# CITY OF ALBUQUERQUE

September 22, 2021

**Re: VCA Vet Care Hospital**  
**8850 Holly Ave NE**  
**Traffic Circulation Layout**  
Engineer's/Architect's Stamp 09-14-2021 (C20-D071)

TCL-001

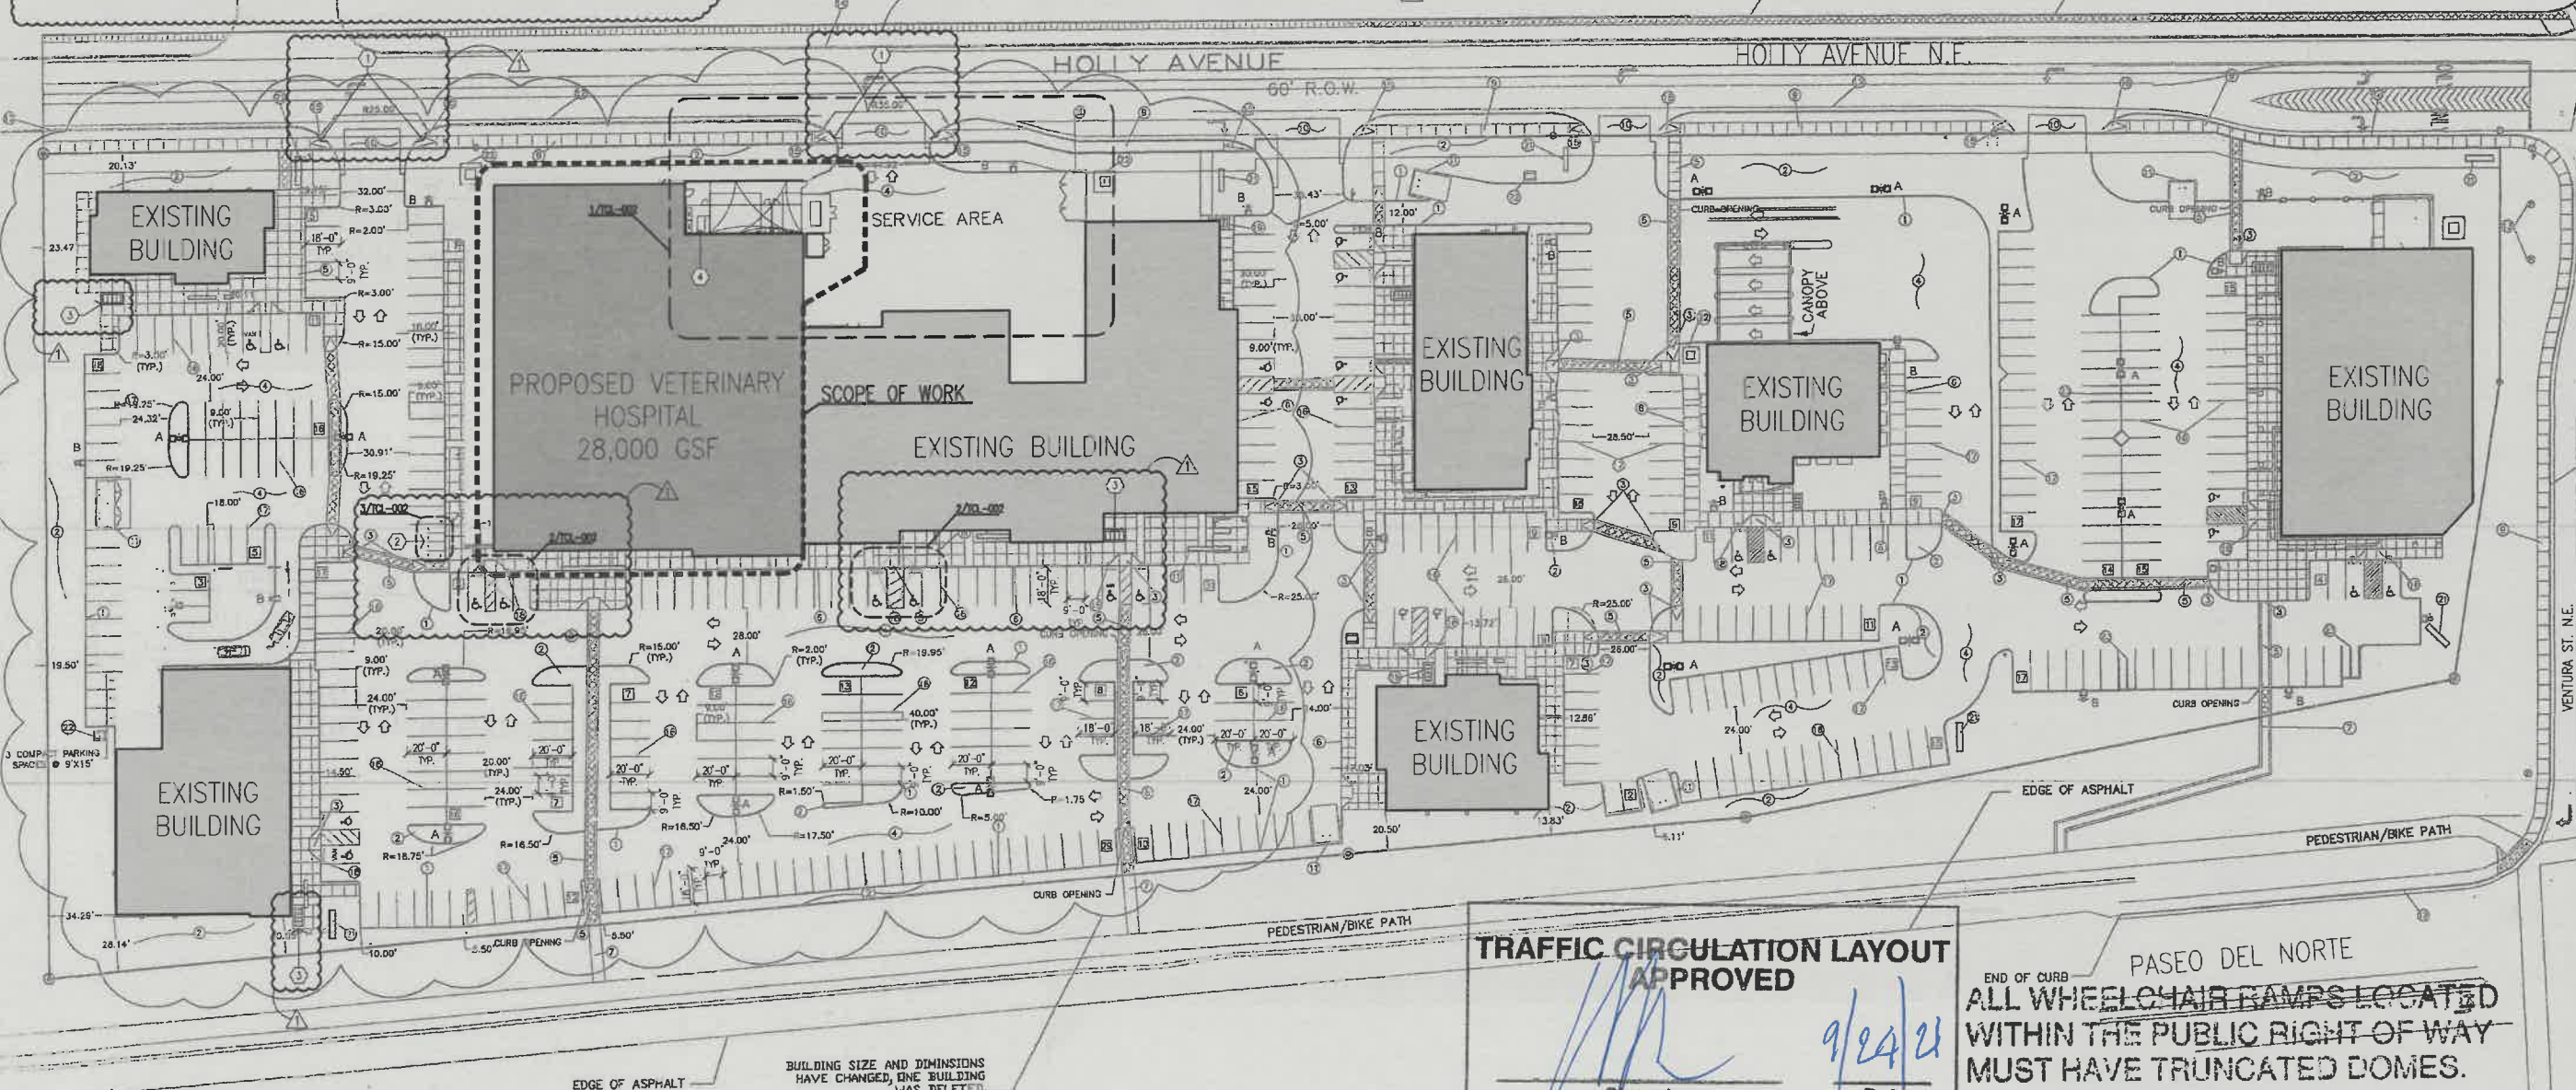
1. Shared Site access: driveways that straddle property lines, or are entirely on one property but are to be used by another property, shall have an access easement. Please include a copy of your shared access agreement with the adjacent property owner **(Prior comment)**.
2. Please provide a letter of response for all comments given.
3. A receipt for Resubmittal Fee of \$75+tax will need to be provided.
4. Traffic Studies: See the Traffic Impact Study (TIS) thresholds. In general, a minimum combination of 100 vehicles entering and exiting in the peak hour warrants a Traffic Impact Study. Visit with Traffic Engineer for determination, and fill out a TIS Form that states whether one is warranted. In some cases, a trip generation may be requested for determination **(Contact Matt Grush: mgrush@cabq.gov). (Prior Comments)**
